Re: Greater Dublin Drainage Project consisting of a new wastewater treatment plant, sludge hub centre, orbital sewer, outfall pipeline and regional biosolids storage facility  
Townlands of Clonshagh, Dubber and Newtown, County Fingal and Dublin City

17 August 2018

DCHG:SID-2018-DF-06

Application by Irish Water for 10 year planning permission for an integrated wastewater treatment project referred to as the Greater Dublin Drainage Project. These works seek to construct a new regional WWTP at Clonshagh, a pumping station at Abbotstown and associated pipelines from Blanchardstown to a final termination point at seabed level approx. 1km north east of Ireland's Eye in the Irish Sea in Fingal, Co Dublin

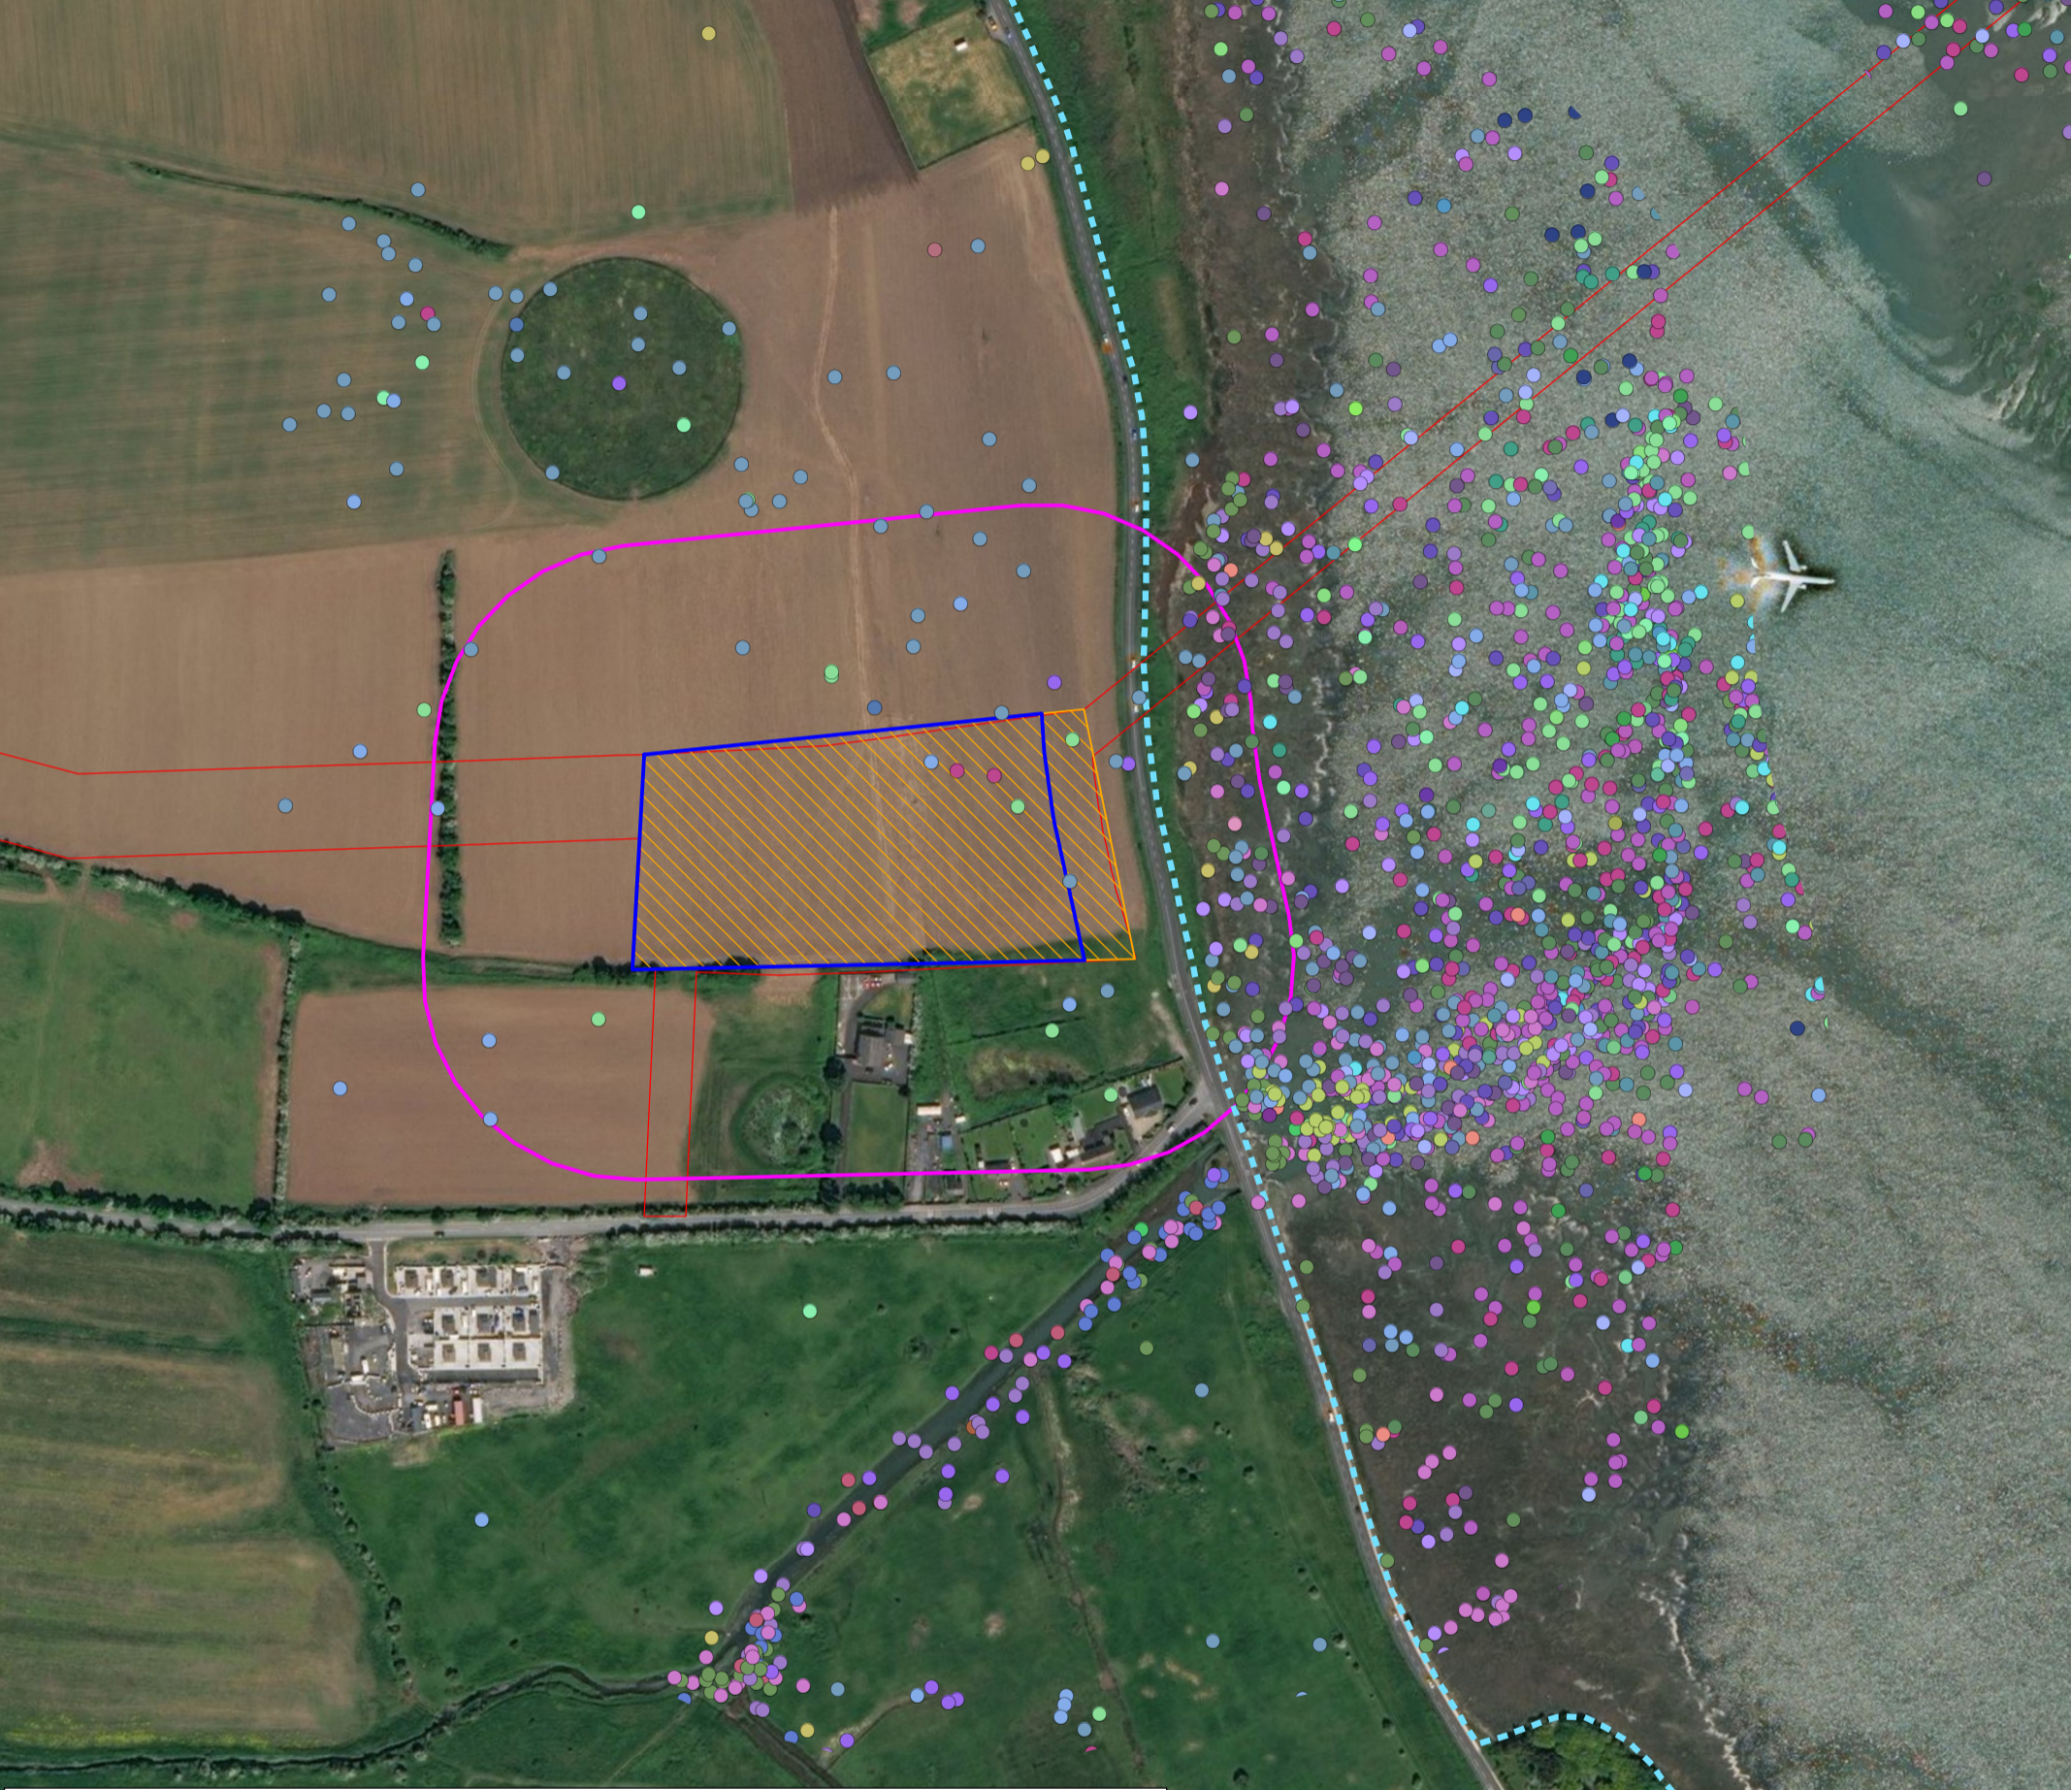
This Department notes that it is stated that 20% of the lands zoned as a quiet zone in the Portmarnock South Local Area Plan (LAP) will be utilised for the proposed temporary construction compound No. 9. This LAP zoned some agricultural lands as residential, but, because of ex-situ impacts whereby birds from the nearby Baldoyle Bay SPA used them for roosting and feeding, areas were set aside for birds in the LAP as mitigation against disturbance and loss of habitat. One such area is the quiet zone for Brent Geese and wader species, which is to be enclosed during the winter months to prevent disturbance. This Department also notes that the access road to this temporary compound will pass through an area also zoned in the LAP for birds, which is to contain arable crops for native and migratory birds. The zoning of these two areas are shown on figure 5.2 of the Portmarnock South LAP entitled "Green Infrastructure and Landscape Strategy".

In carrying out an appropriate assessment, An Bord Pleanála must assess whether the temporary loss of these lands, zoned as mitigation for birds, will negatively impact on wintering birds, when considered cumulatively with the construction activities that have and will be taking place in the LAP lands. In reaching a decision it will need to be determined what other quiet areas will be available for wintering birds in the absence of this 20%, and how the phasing of the residential building might coincide with the construction of temporary construction compound no. 9. While this residential development has been mentioned in the NIS in table 6-11, the cumulative impact does not appear to have been adequately discussed and assessed.
